Consultation Response from KC, Highways Development Management
2025/92671 Butchers Arms, 38, Town Gate, Hepworth, Holmfirth, HD9 1TE
Change of use and alterations to convert first floor to ancillary residential accommodation and additional dining/community meeting space and alterations to convert bathroom at second floor level to storage space (Listed Building within a Conservation Area)
Date Responded: 22/12/2025 Responding Officer: CNB Responding Ref: K12-12/12

This application is for the change of use and alterations to convert the first floor of an existing public house to ancillary residential accommodation and add an additional private dining/meeting room and convert a bathroom to storage.

Parking Survey Area

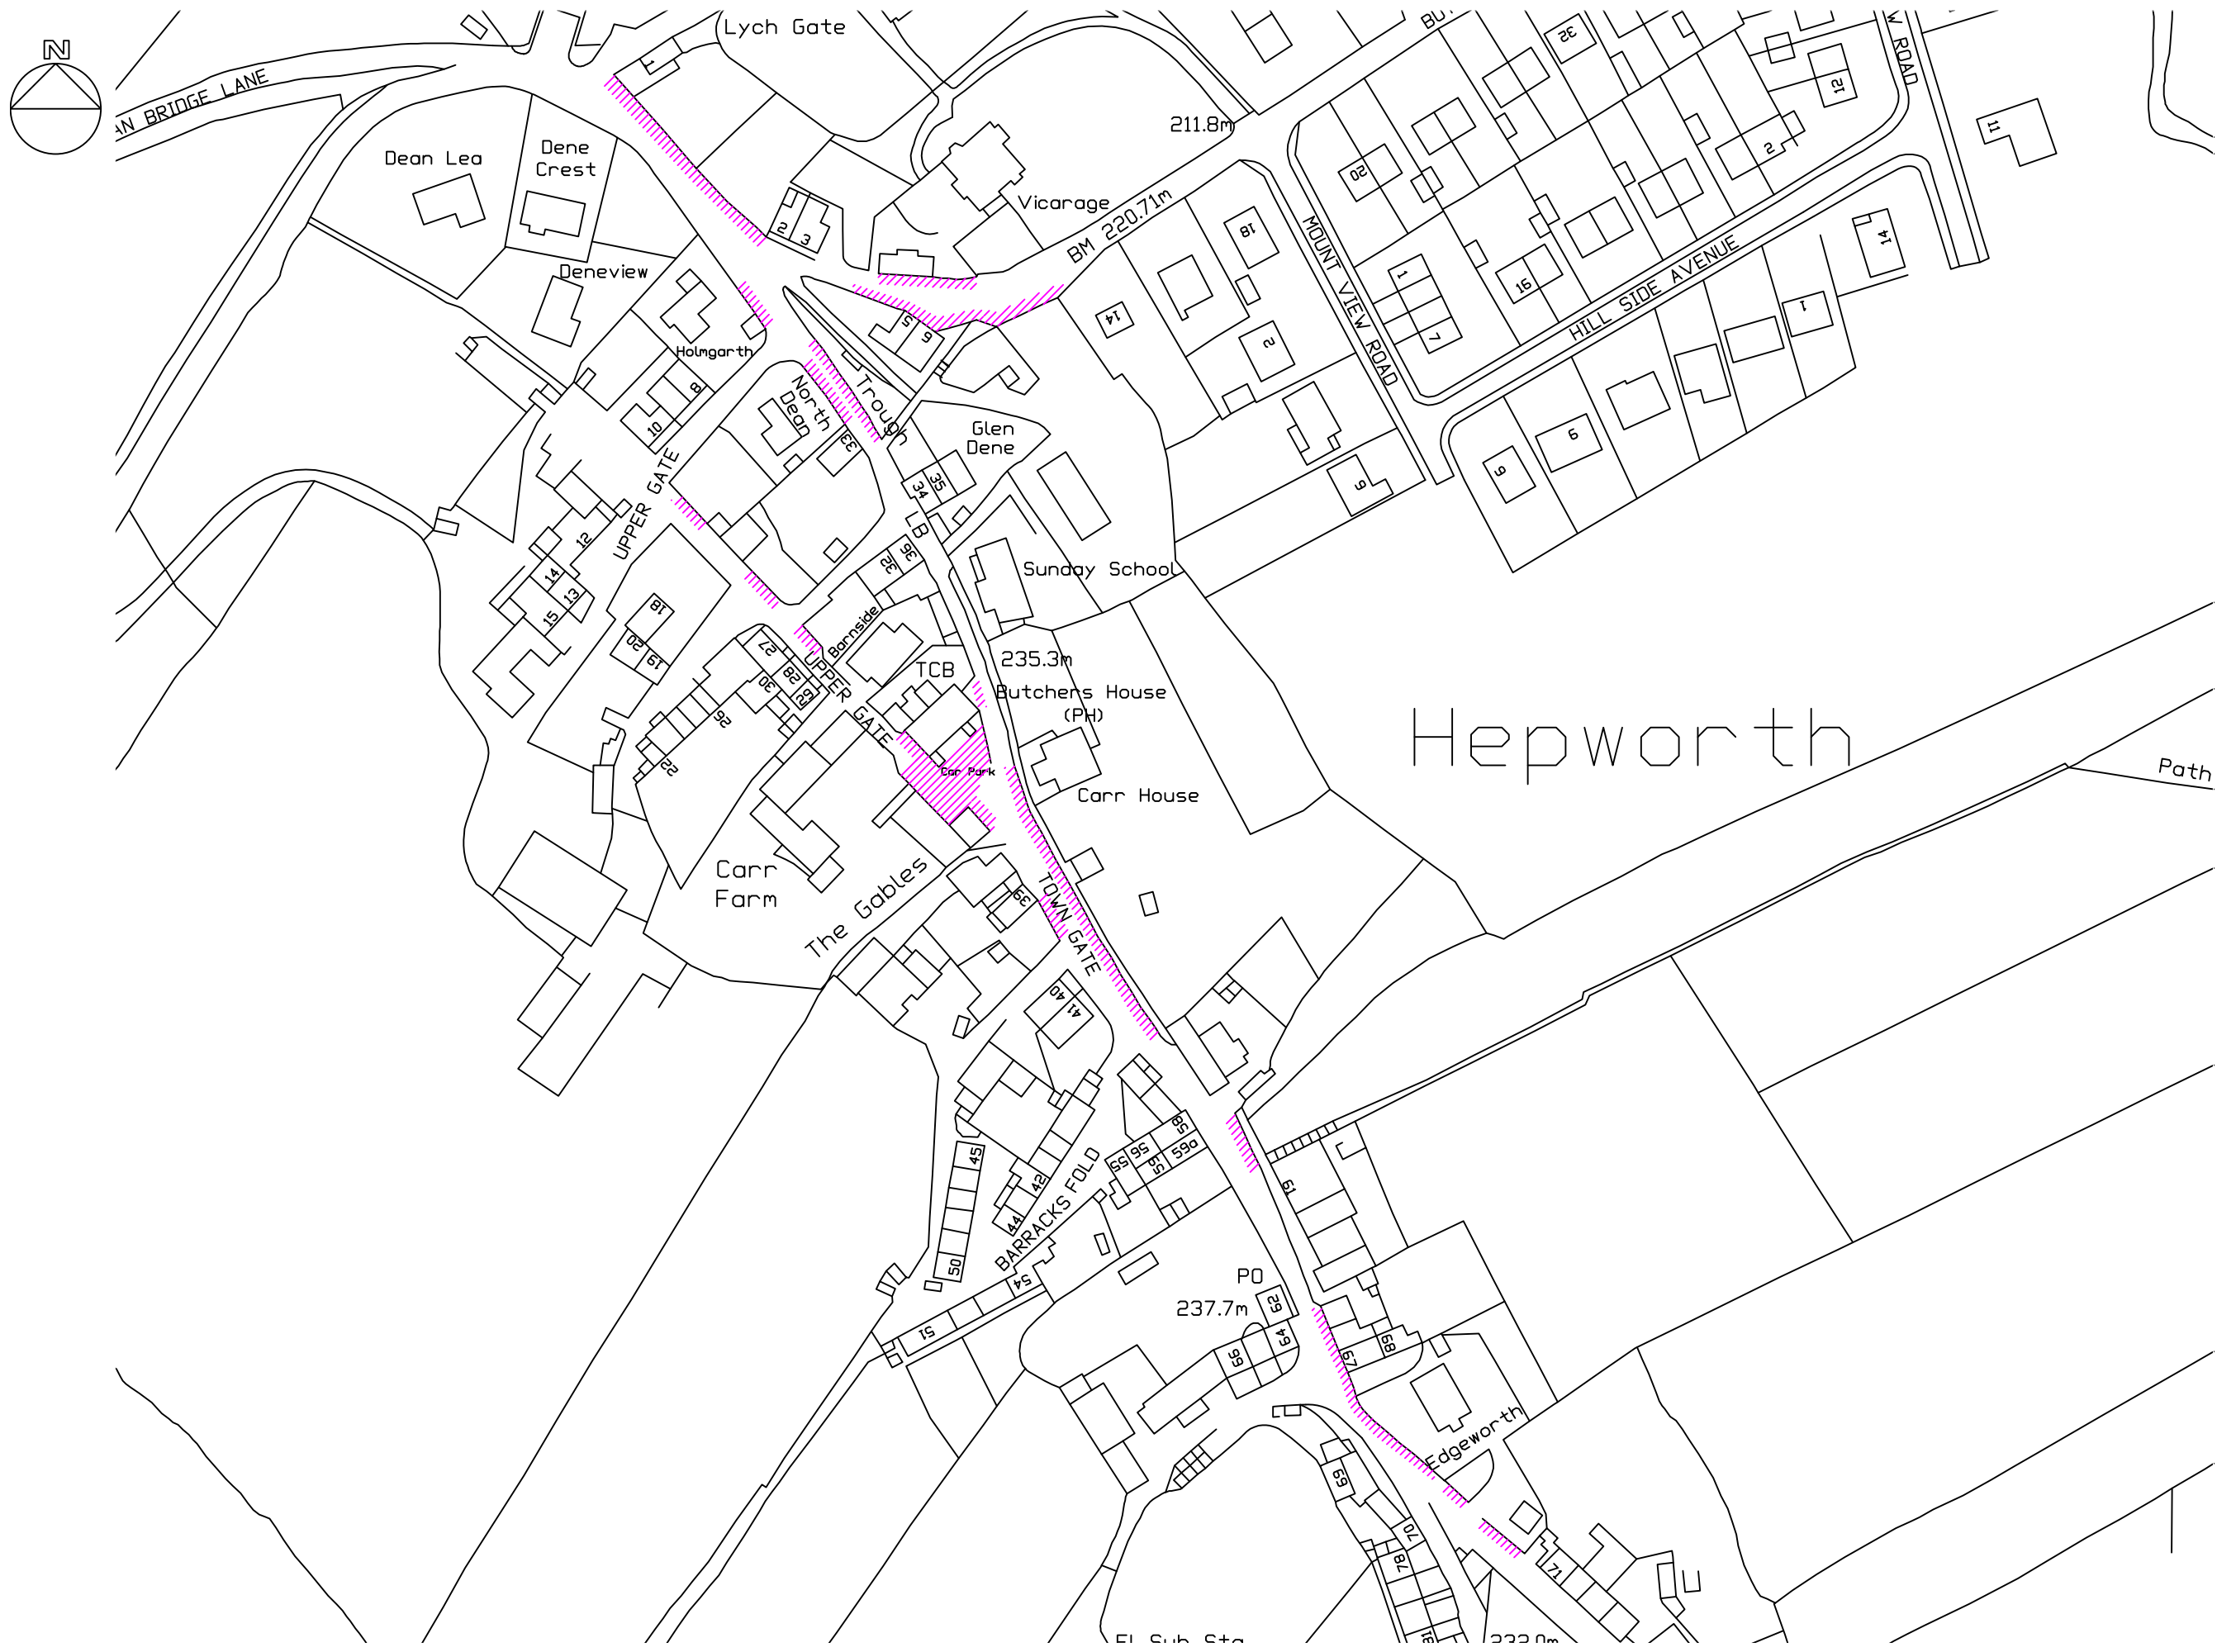
The parking survey identified that there were possible available parking spaces on the following 5 streets (within 200m/2-minute walking distance as per the Lambeth methodology), Dean Bridge Lane (7 spaces), Butt Lane (6 spaces), Town Gate (37 spaces), Upper Gate (10 spaces) and Main Gate (3 spaces), and this should provide approximately 63 on-street parking spaces.

Upper Gate - this is a private road and as such we could not support any parking along Upper Gate and so the identified 10 spaces would not be viewed as usable.

Dean Bridge Lane - it is noted that only 55m of Dean Bridge Lane are within 200m of the proposal site and there is a bus turning head located within this 55m so we consider that only 5 spaces would be reasonable in this location. It should be noted that there is no pedestrian footway on Dean Bridge Lane and the first 84m of Town Gate along the route to the application site.

Butt Lane – Using the adopted highway, there is only 70m of Butt Lane within 200m of the site and most of this is either narrow or on a sharp bend, which wouldn't be suitable for safe parking. There is residential parking and accesses to off-street residential parking and so we would consider a maximum of 3 parking spaces may be available on Butt Lane. It should be noted that Butt Lane is adjacent to Holy Trinity Church and during service times there may be an existing parking demand along here. It should be noted that Butt Lane hosts a medium frequency bus route and any inconsiderate parking may obstruct public transport.

Butt Lane – using a private foot path would increase the amount of Butt Lane within 200m to 110m, although again the section near the junction with Town Gate is narrow and has a sharp bend, however we do not know if access along the private foot path will be made available to all users, although it is currently an application to become a PROW footpath, this is not currently being progressed by the Kirklees PROW team.

Town Gate – This is the longest and widest street within Hepworth, however as a result it also fronts on to the most residential dwellings, most of which do not have off street parking and so there is a high demand for residential parking along Town Gate. There is a section of Town Gate that has No Waiting At Any Time TRO markings as it reduces to approximately 5m width and this TRO extends for 20m. Just to the south of this there is a section of residential parking again with the road narrowing down to 3.5m and so approximately a further 55m are unsuitable for additional on-street parking. There may be some on-street parking to the north of the junction with Far Lane, but this may only be suitable for two cars and is at the furthest extreme of the Lambeth Methodology walking distance. We consider that only the first 55m of Town Gate to the south of the site is suitable for parking, and this will be shared with residents, other users and as the current overflow parking from the existing pub use. To the north of the site there is approximately 42m of road suitable for parking on one side, however this is also outside the Village Hall and may be subject to competing uses, and beyond this there is a narrowing for approximately 33m that is not suitable for parking without the possibility of obstruction occurring. Beyond this, to the northern end of Town Gate there is approximately 30m where on street parking could occur. This may provide on-street parking along the full length of Town Gate for approximately 22 cars, although these will be shared with residents parking and competing users.

Main Gate – The only section of Main Gate that is within the 200m walking distance from the application site is just to the southeast of the junction with Far Lane and any parking here is likely to obstruct the right turn movement out of Far Lane. There may be some car parking further to the southeast on Main Gate but this is beyond the 200m limit of the Lambeth Methodology and is beyond the far end of the village centre and is unlikely to be used by visitors to the pub.

This suggests that of the streets surveyed, there would only be approximately 30 parking spaces available to be used by visitors to the pub, and it should be known that these will be in competition with

other users within the village, such as the Village Hall, residents and visitors. This is approximately half of the number of spaces identified in the survey.
